# City of Albuquerque

RE: DRAINAGE PLAN FOR AN ADDITION TO STATKUS ENGINES (J-14/D81)  
RECEIVED 11/14/88 ENGINEER'S STAMP DATED 11/14/88

W. Reed Edgel, M.S., P.E. CONSULTING ENGINEER 601 VASSAR DR NE ALBUQUERQUE, NM 87106 (505) 255 2675		
STORAGE BUILDING STATKUS ENGINES		
JOB # 88019	LEASE-A PORT/JAMES STATKUS	11/3/88
1/16" = 1' 0"	SIZE C	SH 1 OF 2

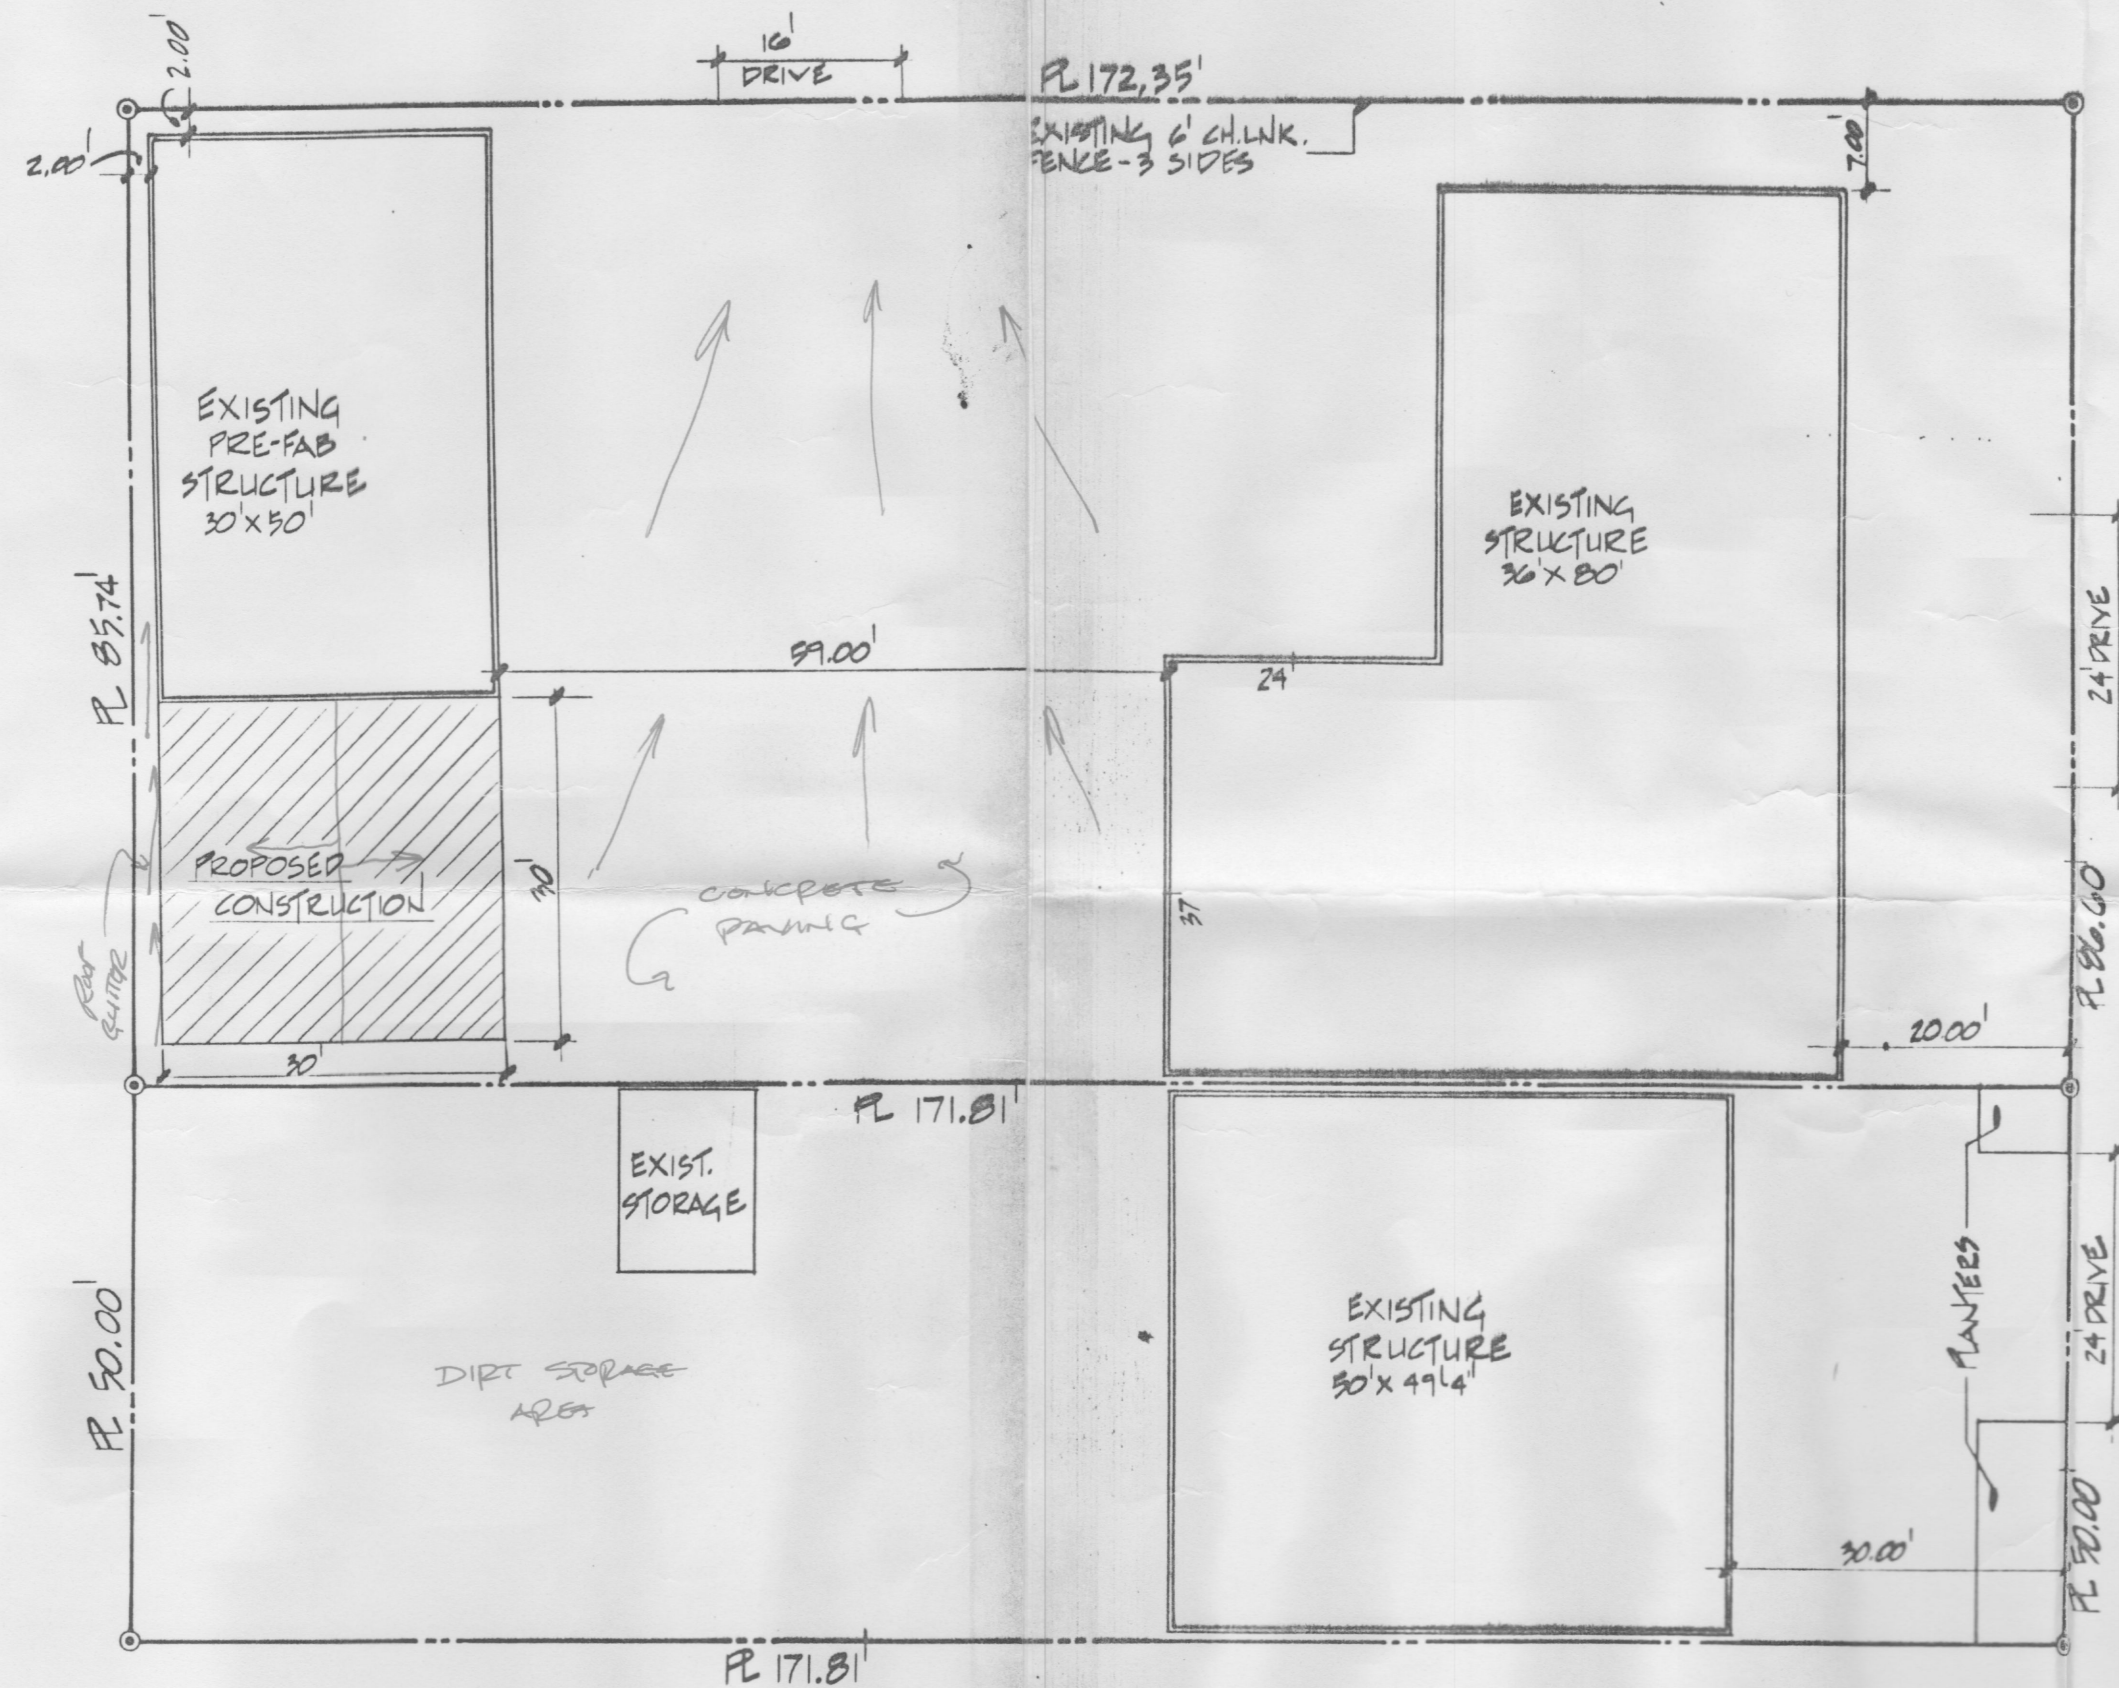
1. Finish floor elevation to full mean sea level designation of proposed building and existing.
2. Location, description and elevation of:
  - a. ASC bench mark used;
  - b. T.B.M. located on site.
3. Roof drainage of proposed building must be routed towards the concrete paved area.
4. Few spot elevations to demonstrate how the runoff will be routed towards Aspen Street.
